SY171708-18_B01

Re: Macquarie Park Stage 2 – “Building E” SSDA (SSD – 63235720) – Response to Flooding Related Request for Information

Response to City of Ryde Request for Further Information

Figure 4: Flooding impact on Talavera Road (Source: Northrop)

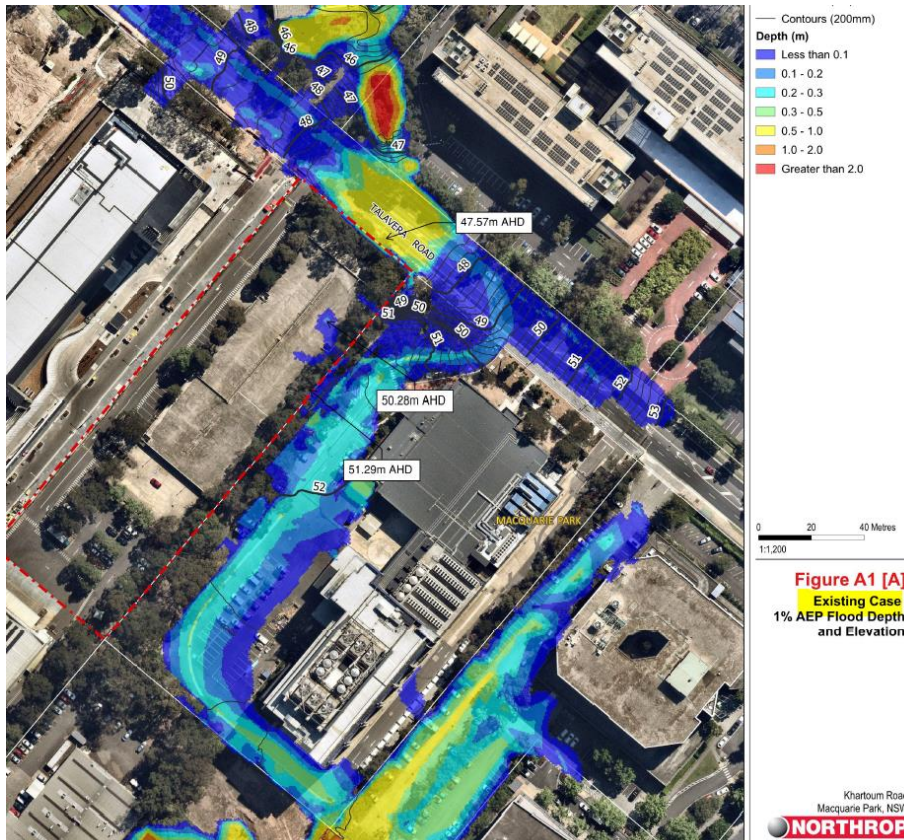
...The below figures are from the June 2025 Flood study that shows the site is PMF free however demonstrates adverse increased flood on adjoining sites & possibly Talavera Road.

Figure 4 shows that In Northrop's Report dated January 2025, the site was affected by PMF, however when compared to their Report Dated June 2025 (Figure 6) the site is not longer affected. This flood water appears to have diverted (due to the built form) to adjoining site (17-23 Talavera Road) resulting in adverse flood behaviours. This is unacceptable increase of flood within neighbouring property.

The flood modelling presented in the January version of the Flood Report (i.e. Revision B) was prepared prior to approval of the Modification for 17-23 Talavera Road (REF: SSD – 24299707-Mod-1). Since the preparation of Revision B of the report, the Modification for 17-23 Talavera Road (REF: SSD – 24299707-Mod-1) has been approved.

Following approval of the development at 17-23 Talavera Road, the existing case flood behaviour for the subject site is based on the approved developed case scenario for 17-23 Talavera Road (REF: SSD – 24299707-Mod-1). This scenario renders the subject site generally flood free during both the 1% AEP and PMF design storm events.

As the site no longer experiences overland flow, the proposed development is not expected re-direct or remove flood storage and therefore is not expected to create a significant adverse flood impact.

Please refer to the above response.

The site no longer experiences overland flow and therefore the proposed development is not expected to re-direct or remove flood storage and or create a significant adverse flood impact.

Figure 5: Stormwater Pipe to be upgraded shown In orange (Source: City of Ryde Council)

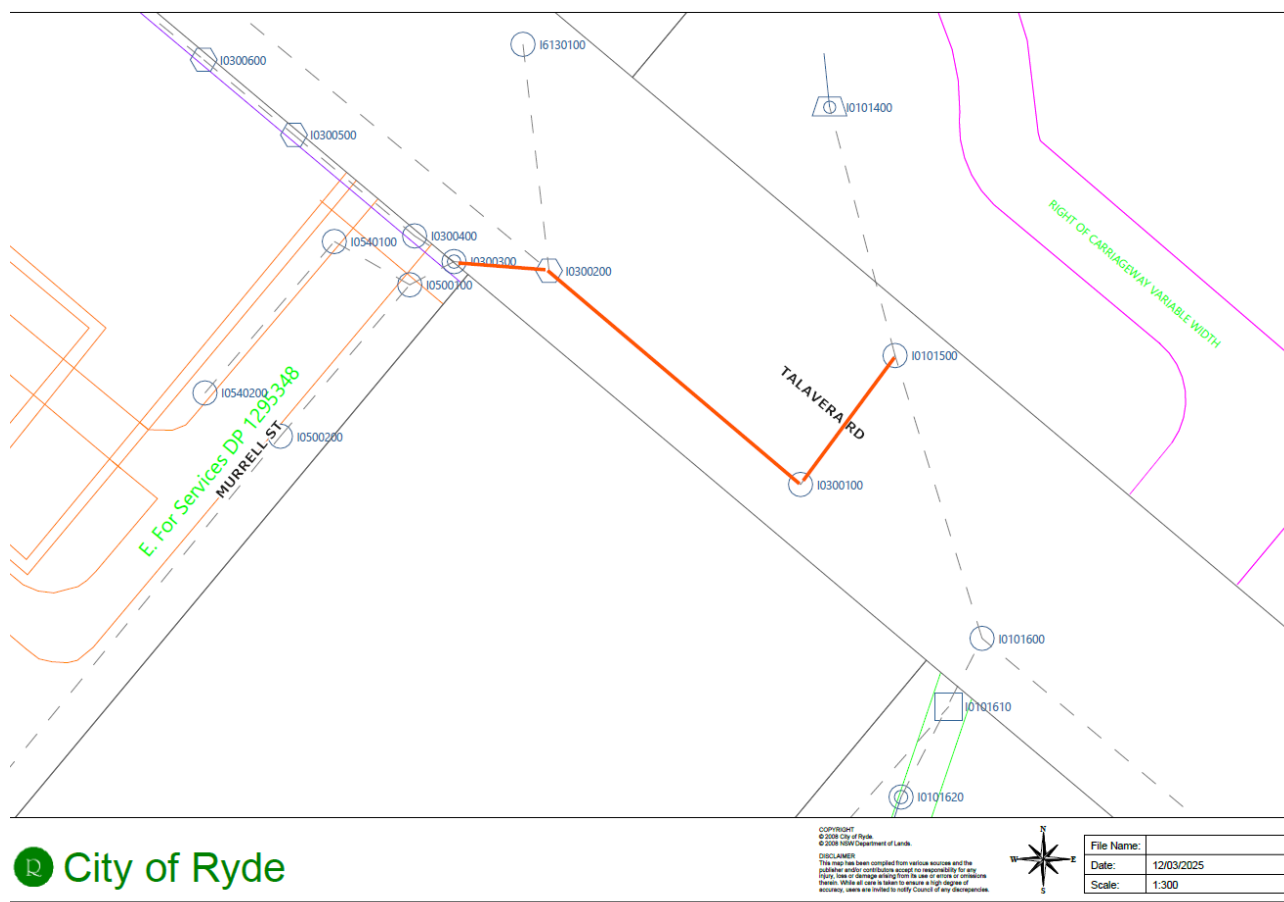
As result of the above concerns to effectively resolve Council flooding concerns, Council recommends that the upgrading of Council drainage system as previously advise is required. Further details below.

While the upstream drainage system within 17–23 Talavera Road has been upgraded, the absence of corresponding improvements downstream within Talavera Road has created a hydraulic bottleneck directly in front of the site. To reduce the risk of surcharge-related inundation and protect essential infrastructure, Council requires an upgrade to the stormwater drainage system at the site frontage.

As noted in the FIRA (Northrop, 2025), during the Meeting on 25th of August 2025, and above, the proposed development is not expected to create a significant adverse flood impact within Talavera Road, or elsewhere.

As such, the requirement to upgrade Council's stormwater network is not expected to be required.

With respect to Item 2 above, a blockage sensitivity test has been performed using the modelling presented in the FIRA (Northrop, 2025).

For the purposes of the sensitivity test, the inlet blockage of the stormwater pits within Talavera Road at the site frontage, were increased to 90% to represent a severe blockage scenario. The results were then compared to the modelling that is already presented in the FIRA (Northrop, 2025). Both the 1% AEP and PMF design storm events were considered for the analysis.

Based on the above, and the results presented in Figures 1 and 2 of Attachment 1, the flood levels in Talavera Road are not expected to be sensitive to blockage during both the 1% AEP and PMF design storm events.

With a freeboard of approximately 2.22m and 1.60m above the 1% AEP and PMF flood levels in Talavera Road, and negligible change observed by the sensitivity test performed herein, blockage in Talavera Road is not expected to significantly impact the proposed development.
